CITY OF ALBUQUERQUE

RE: **Biopark- Carousel Area**
COA Zoo
Grading and Drainage Plan
Engineers Stamp Date 4/10/15 (K13D034E)

Based upon the information provided in your submittal received 5/20/2015, the above referenced Grading and Drainage Plan cannot be approved for Grading Permit or Building Permit until the following comments are addressed.

SHEET NUMBER
C2.1

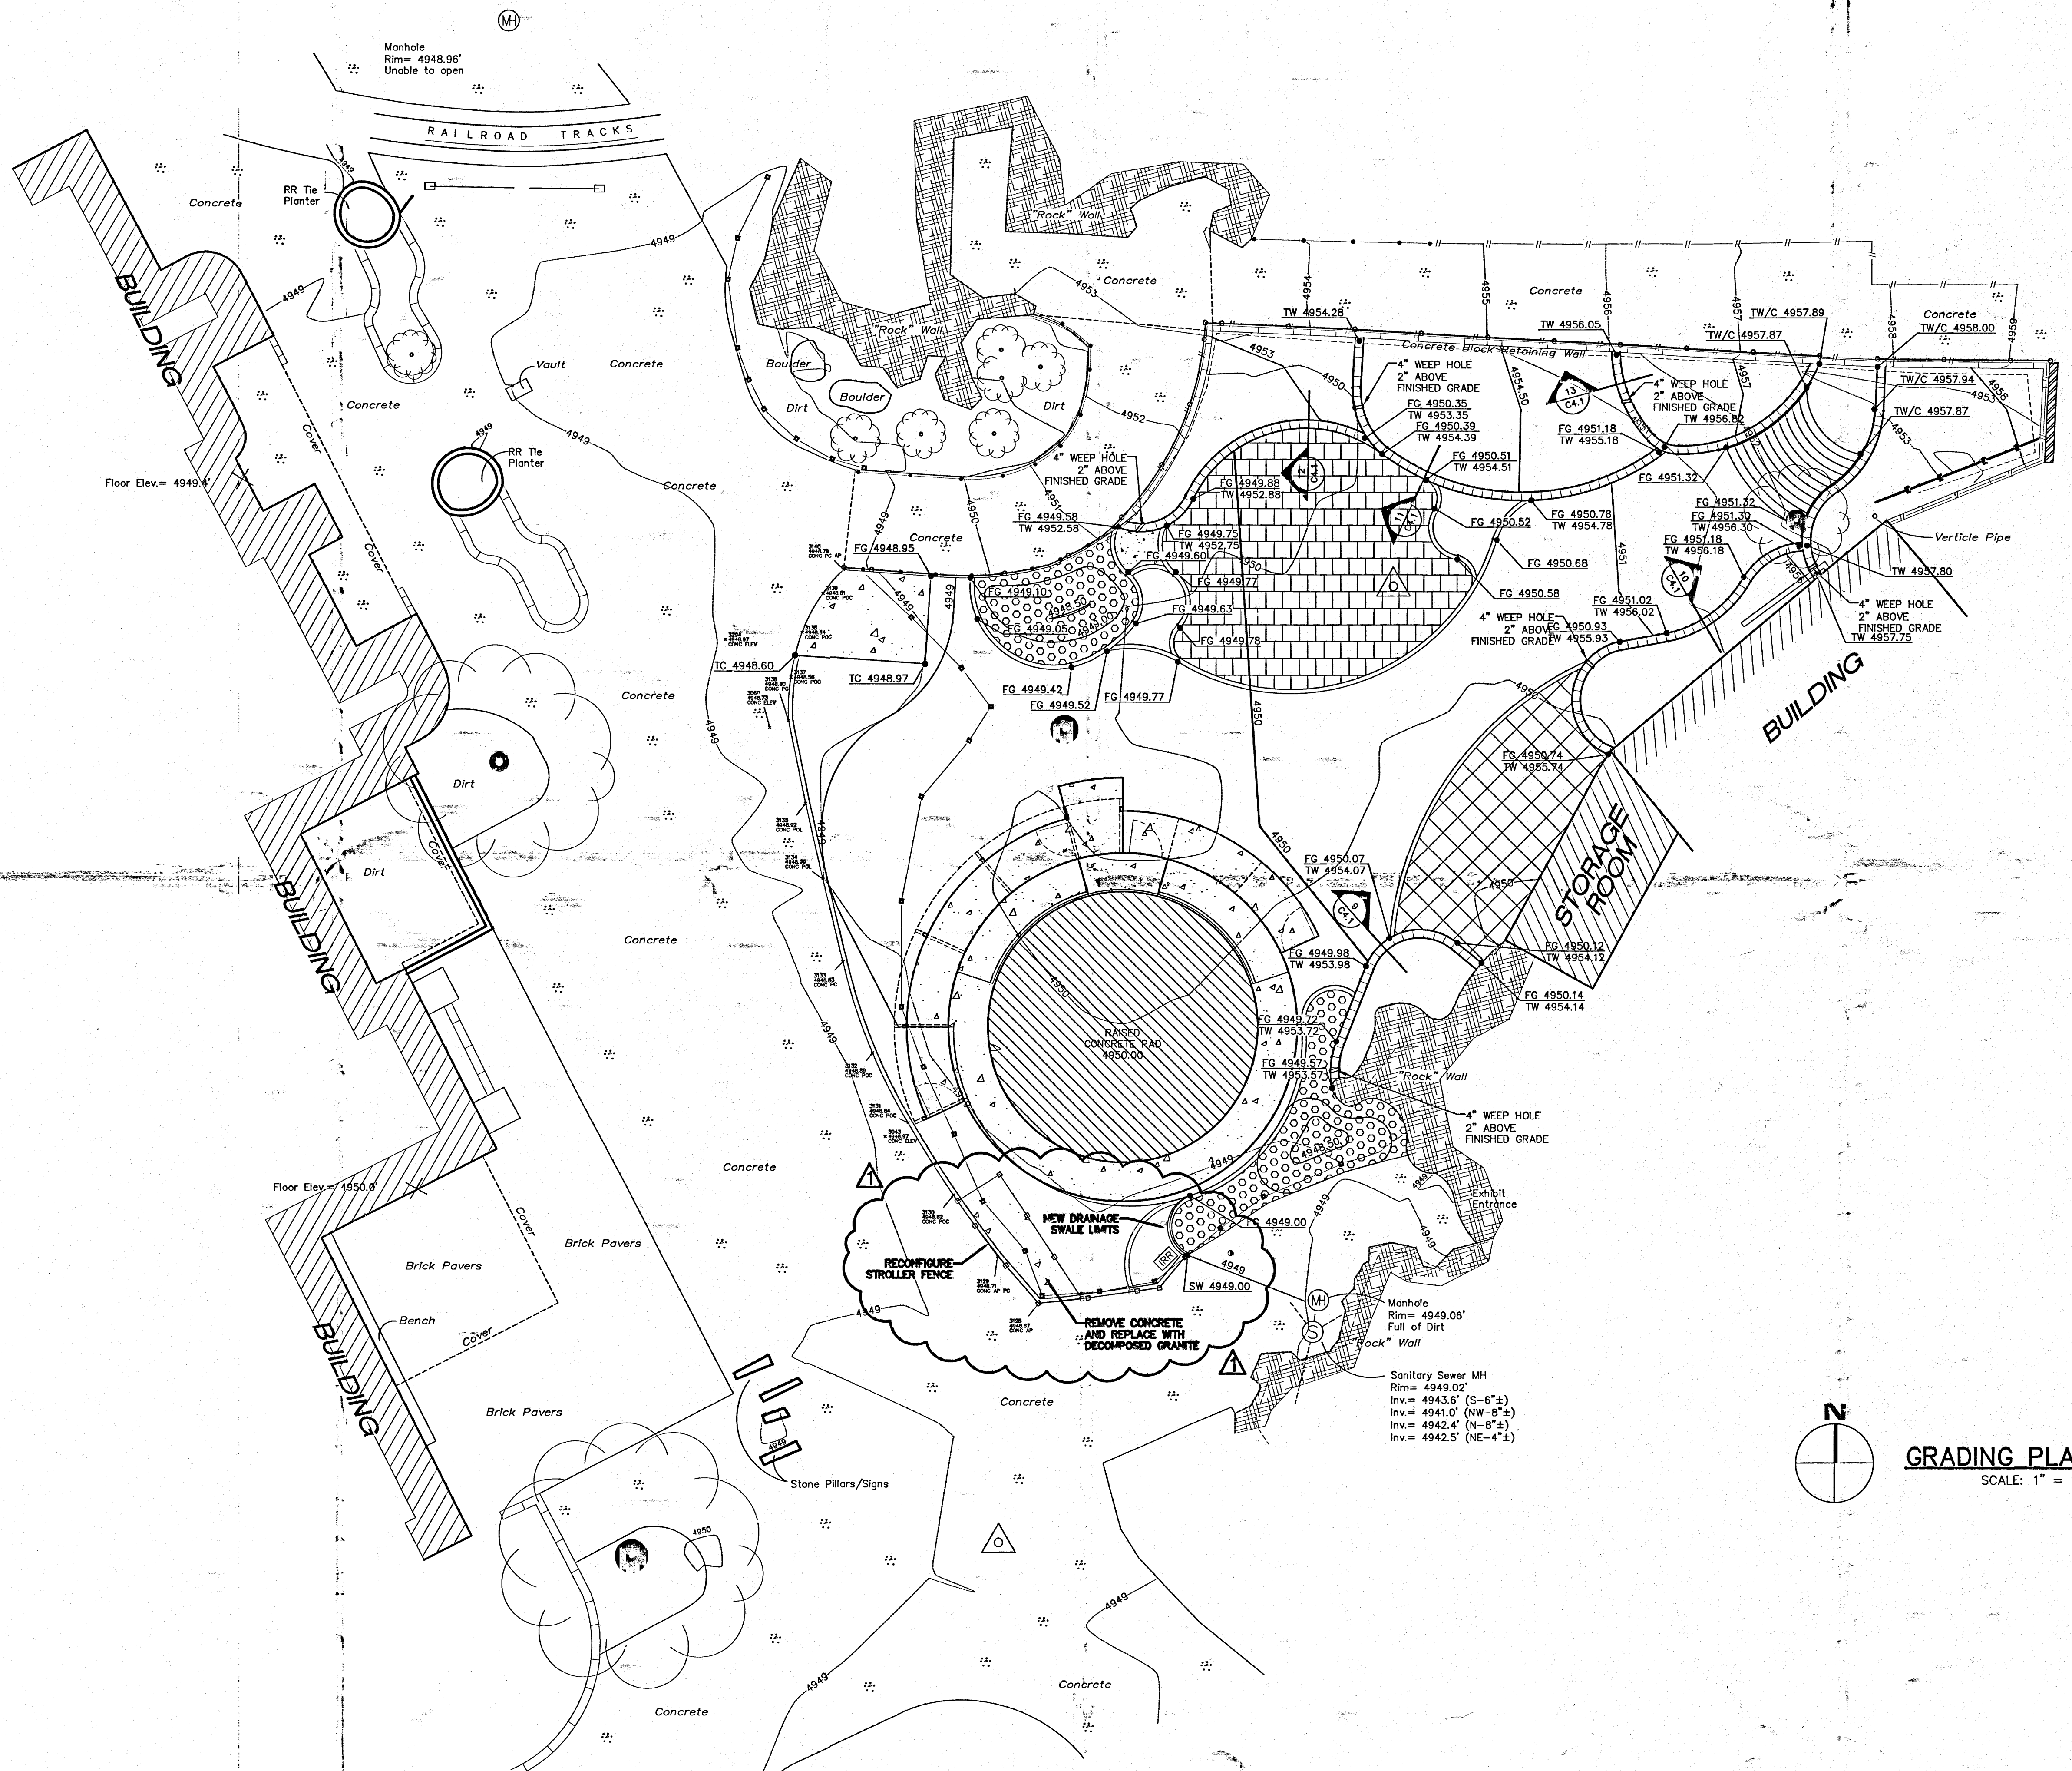
- Provide a site plan and FIRMette of this location.
- Provide a table of calculations for land treatments, percentages, existing and proposed flows.
- Provide a legal description of this site.
- Show or mention the location of the bench mark.
- Provide how flows will leave this area.
